Application No: EP/35/21/HH
Site Address: 46 Manor Road East Preston BN16 1PY
Description of works: Rear extension, associated works, new porch, replacement of fenestration and erection of solar panel array.

OWPC36474

I am commenting on this application on behalf of the East Preston and Kingston Preservation Society.

Front Boundary Wall Elevation (North) 1:100

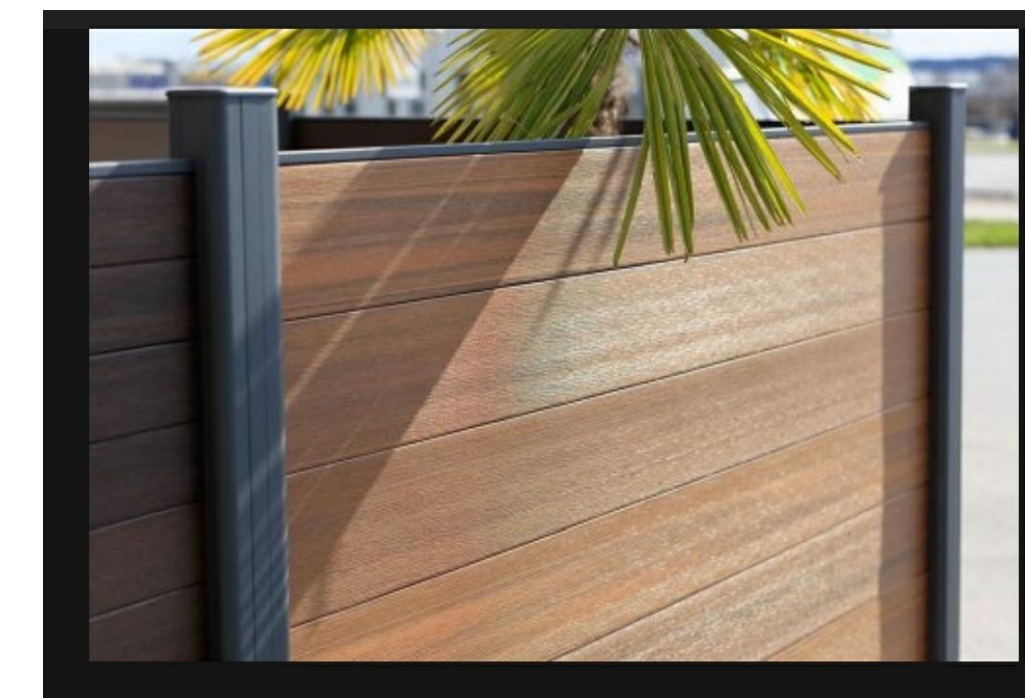
The proposed front boundary treatment is, however, inappropriate. The combination of a low wall faced with fibre cement panels and black aluminium railings of unspecified height - but possibly 1.8 metres - above the wall would be urban in style, unattractive in appearance, and completely out of character in the area.

This proposed boundary treatment is contrary to Policy D DM1 of the Arun Local Plan, because the landscaping does not reflect the character of the area; and it is contrary to Policy 2 of the East Preston Neighbourhood Plan, because it would not preserve the existing street scene.
